CITY OF ALBUQUERQUE

**RE: Sigma Chi Parking Lot
Grading and Drainage Plan
Engineer's Stamp Date – 8-2-2016
Hydrology File: J15D098**

Based upon the information provided in your submittal received 8-2-2016, the above referenced Grading Permit submittal is approved for Grading with the following conditions:

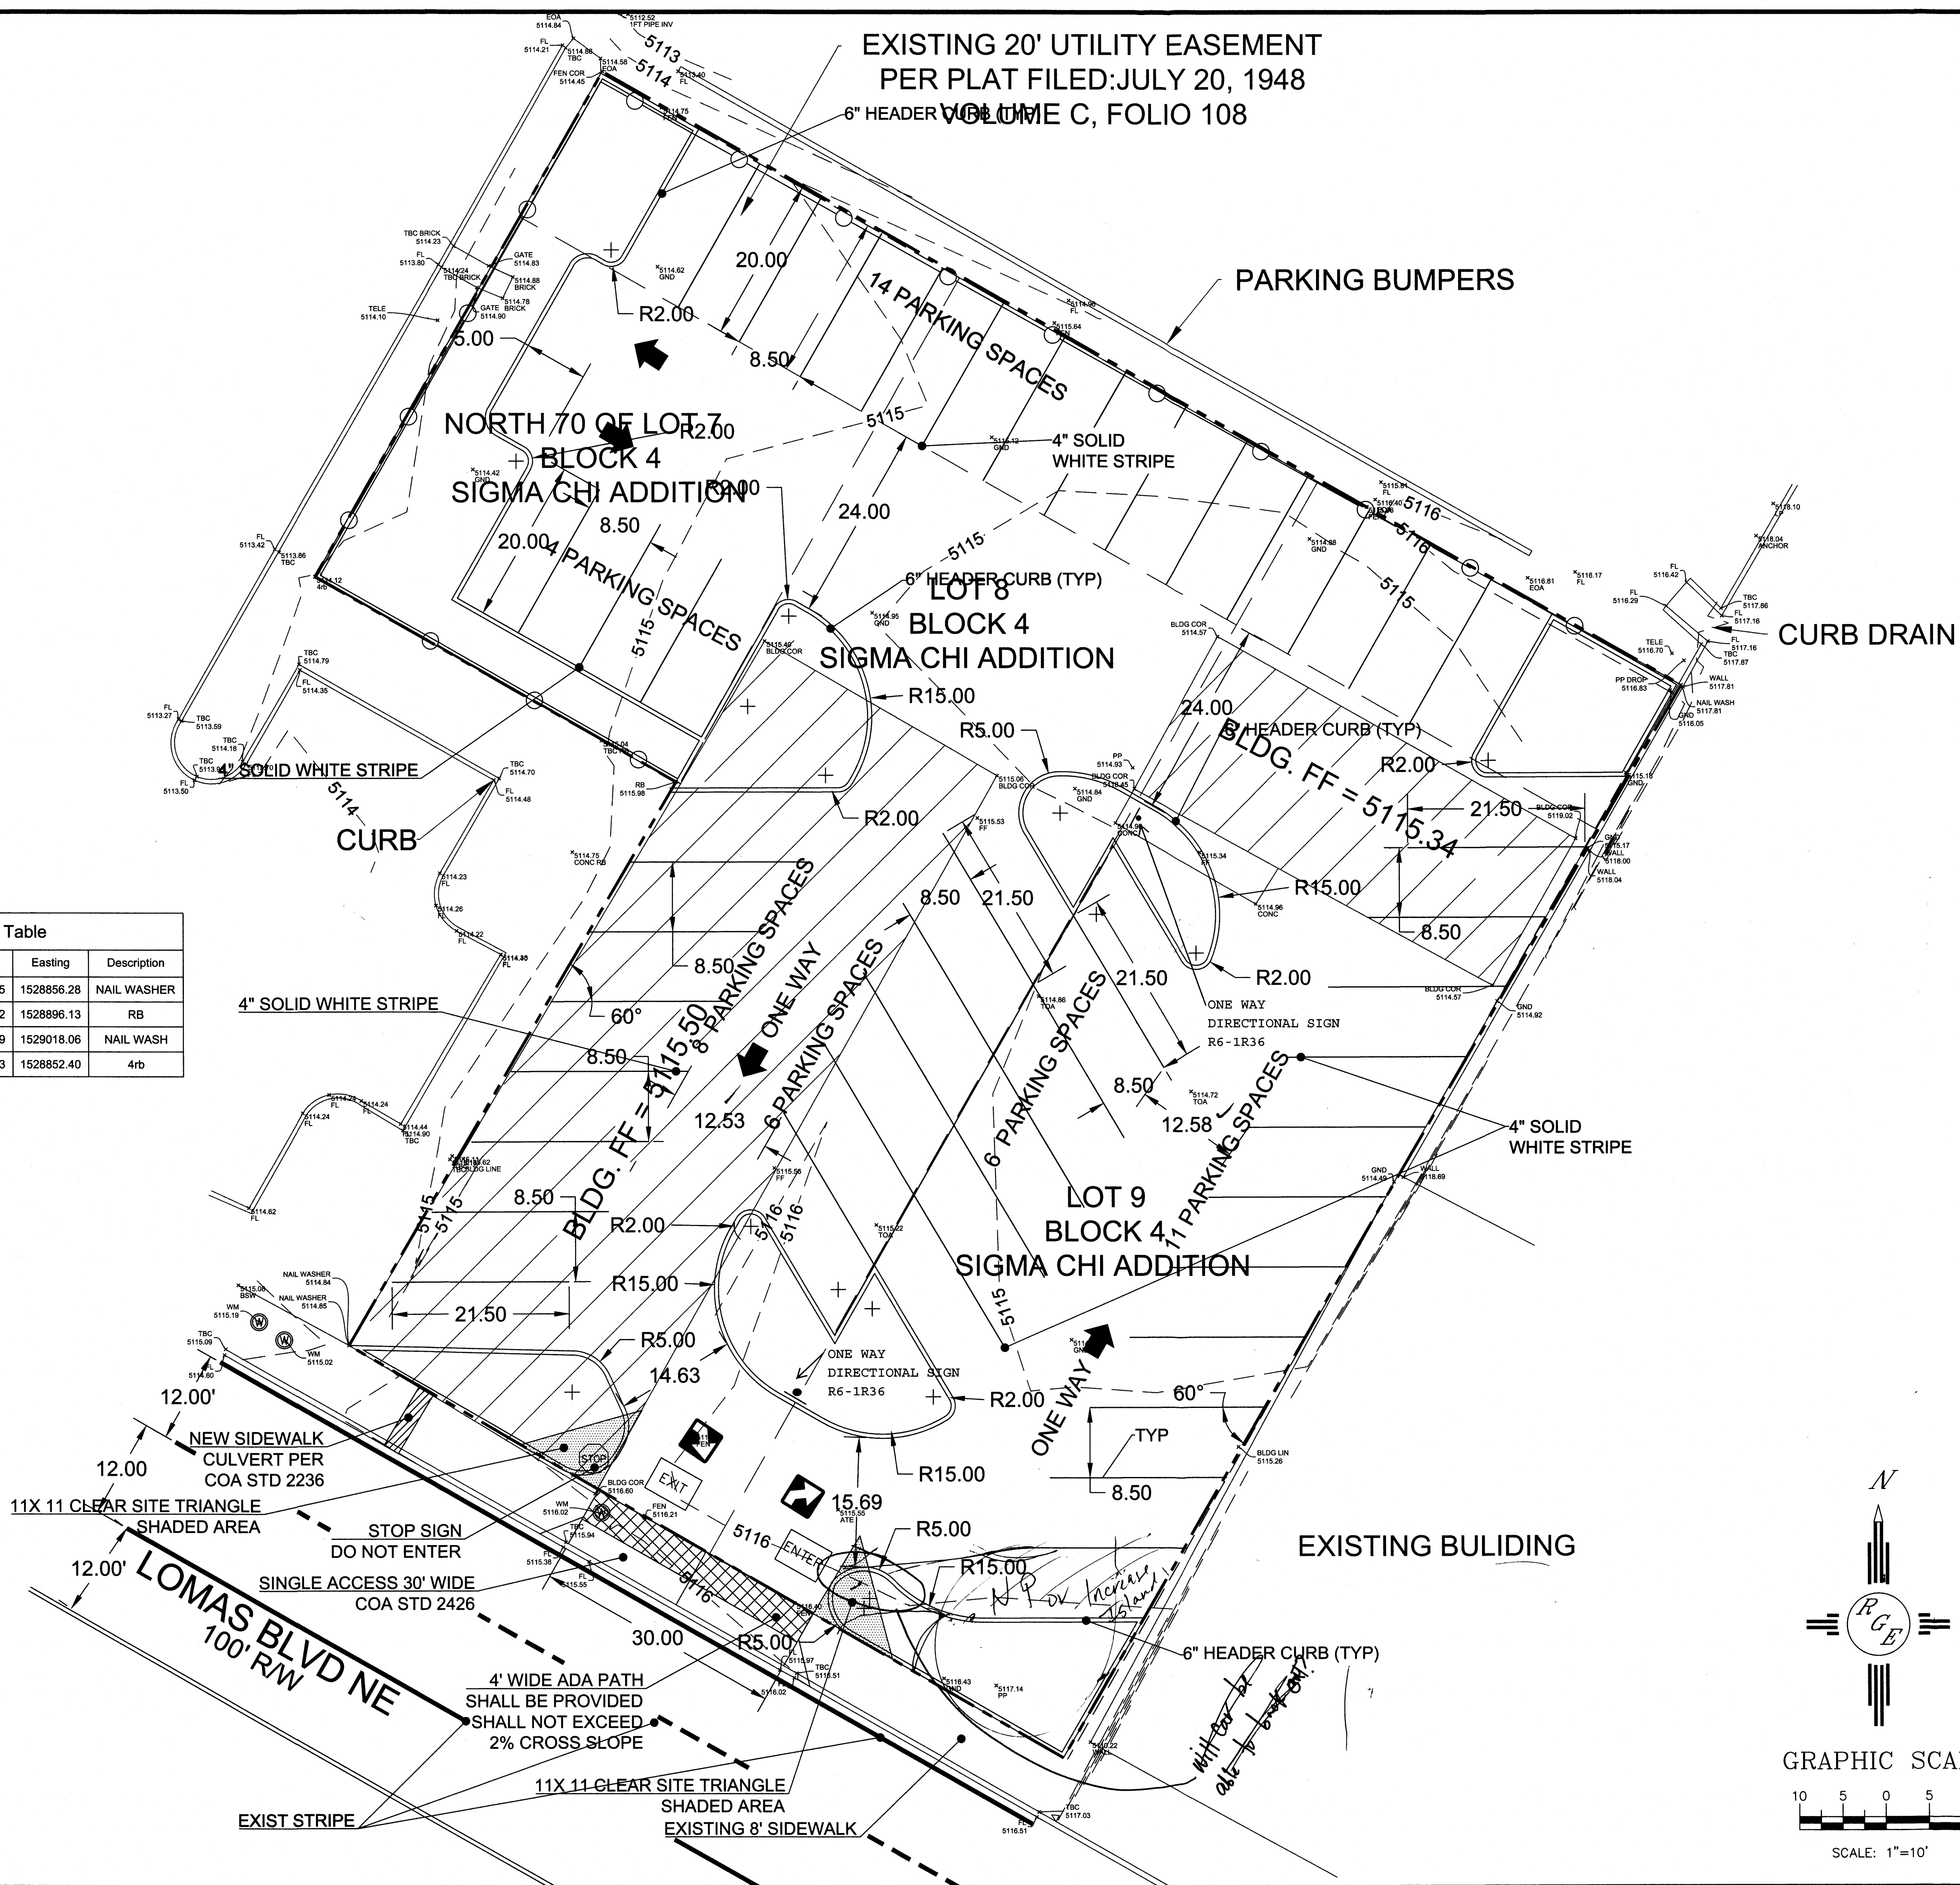
1. Remove the 4" pvc drain that is proposed through the sidewalk, which would require an SO-19 Permit. Instead, a curb cut outlet facing the driveway can provide a spillway for the adjacent pond.
2. Ensure that curb cuts are constructed on all the islands at logical low spots; some are not shown on the plan.
